Subject: RE: Planning Consultation on BE/21/20/DOC

Engineers comments in respect to surface water drainage;

APPLICATION NO: BE/21/20/DOC

Site Address: Land At Salt Box West Of Shripney Road Bognor Regis PO22 9NW

HYDROCK PROJECT NO.	SCALE @ A1
C-13319-C	AS SHOWN
STATUS DESCRIPTION	STATUS
ISSUED FOR CONTRACT	D2
DRAWING NO. (PROJECT CODE-ORIGINATOR-ZONE-LEVEL-TYPE-ROLE-NUMBER)	REVISION
SAL-HYD-PH2-ZZ-DR-C-7101	P05

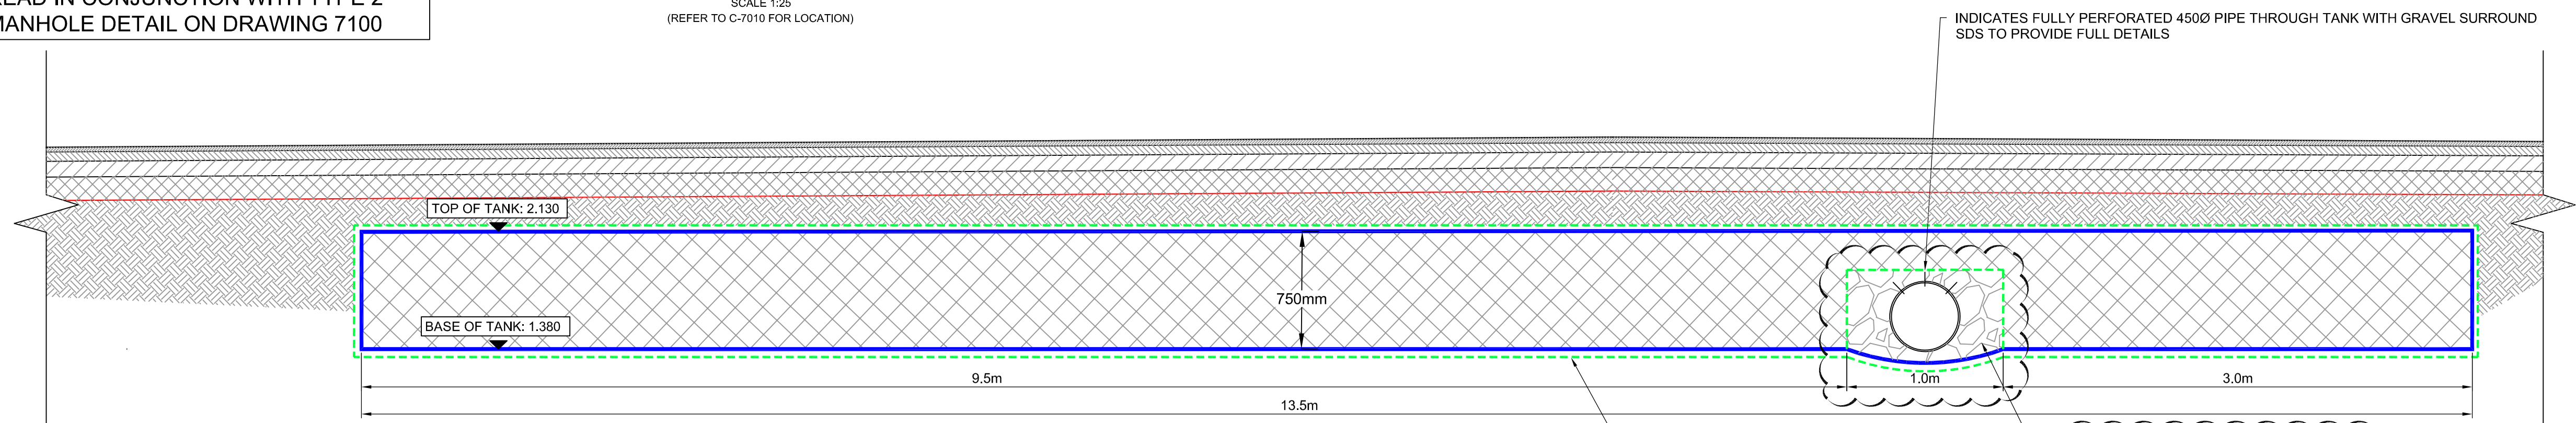
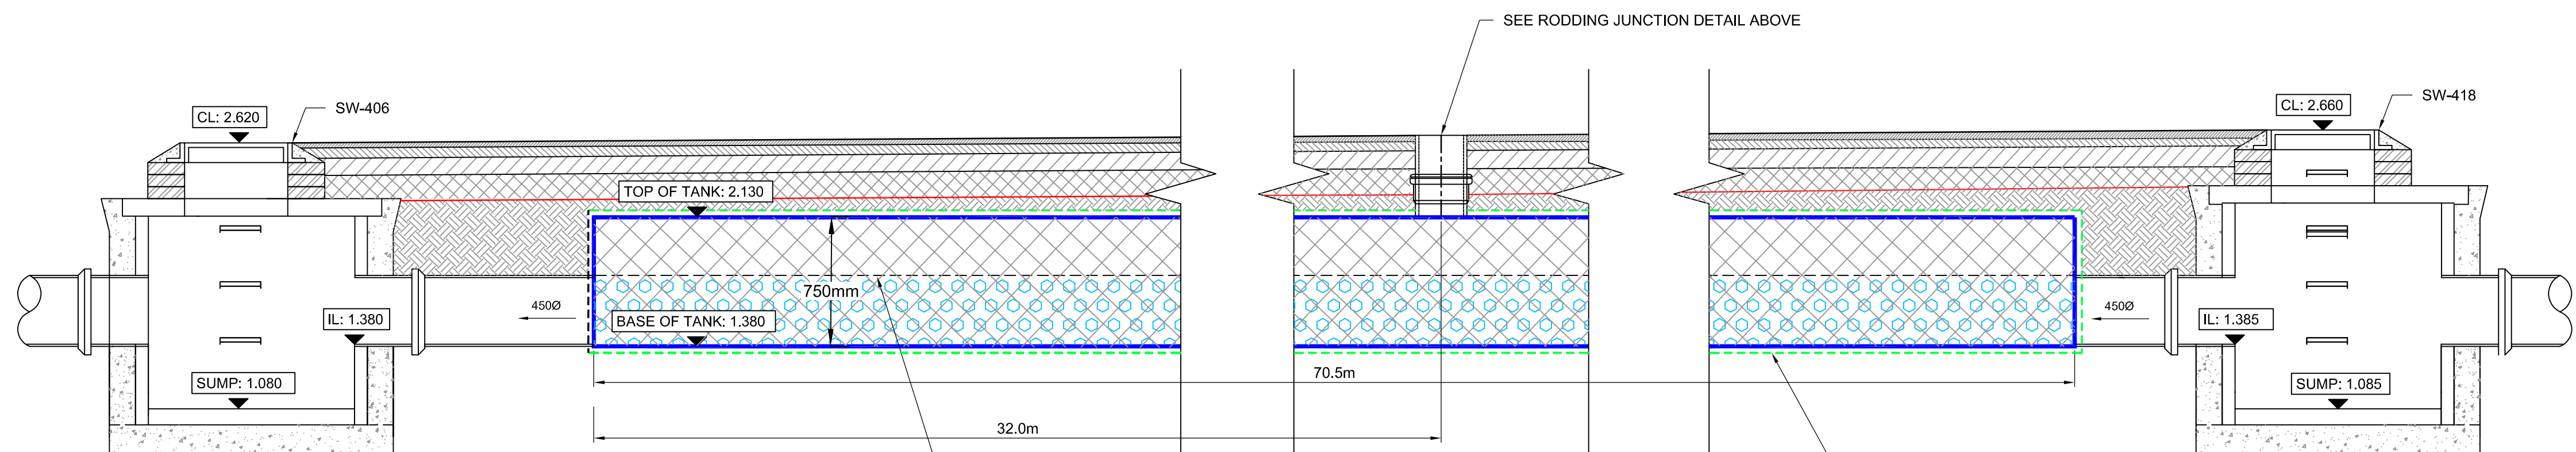
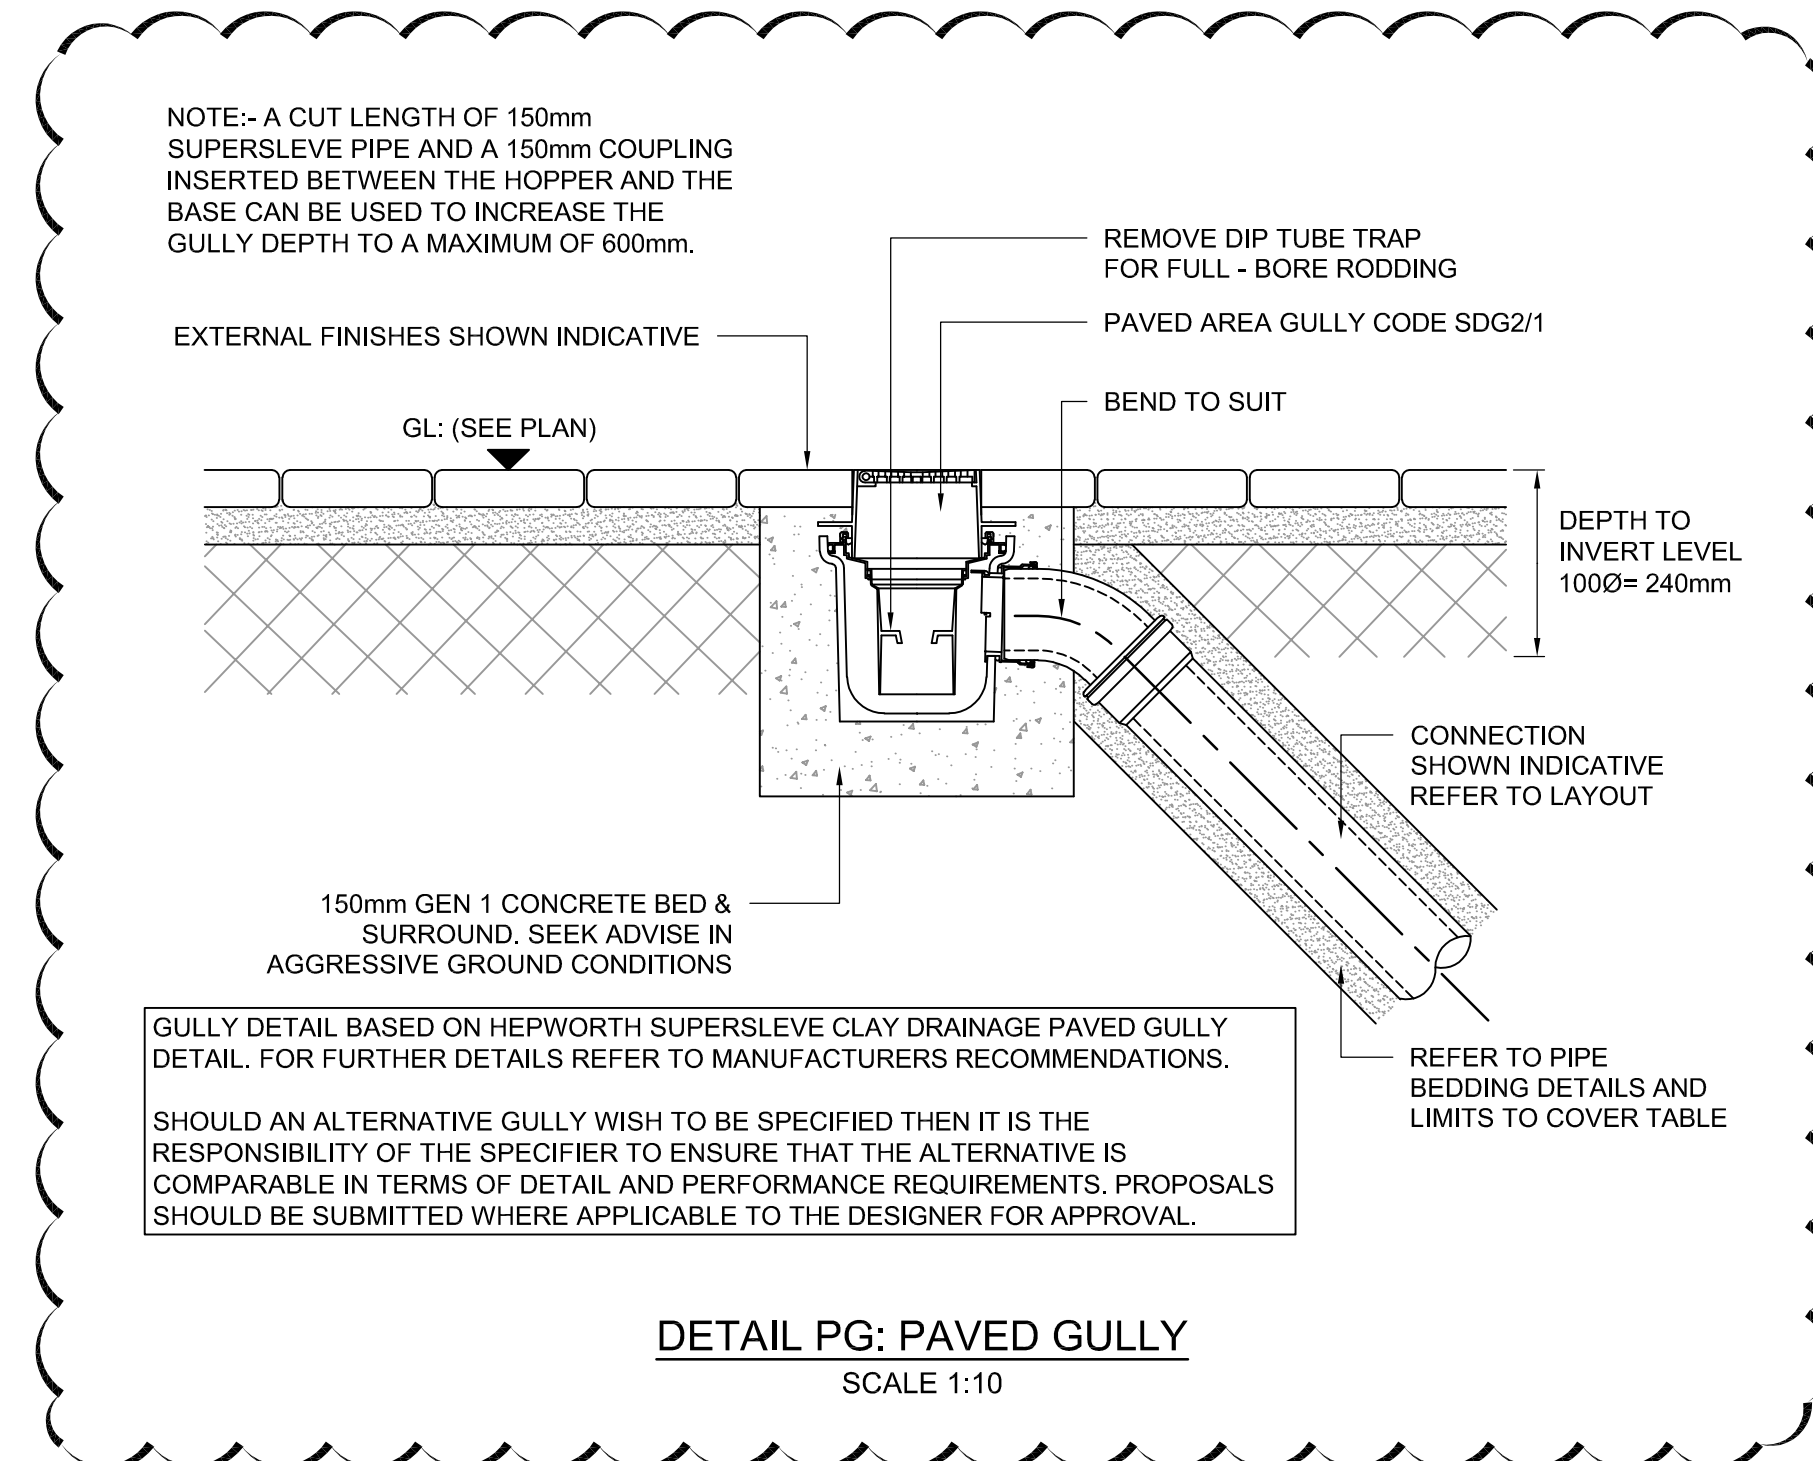
16. Drawing 7103 (Phase 2)– Section 2-2 – should this be labelled AT-401?
17. Drawings 7103 (Phase 1 & 2) ie. AT-201 and AT-401 – specify granular surround to pipe including thickness. Provide permeable geotextile wrapping to bedding.

18. AT-401 – Provide integral catchpit manhole in crates at connecting junction as opposed to a 300mm vertical pipe.
19. Drawings 7101 & 7102 – there are slightly different versions (phase 1 and phase 2) – create just one drawing for 7101 and one drawing for 7102 as they are pretty much applicable to both phases.
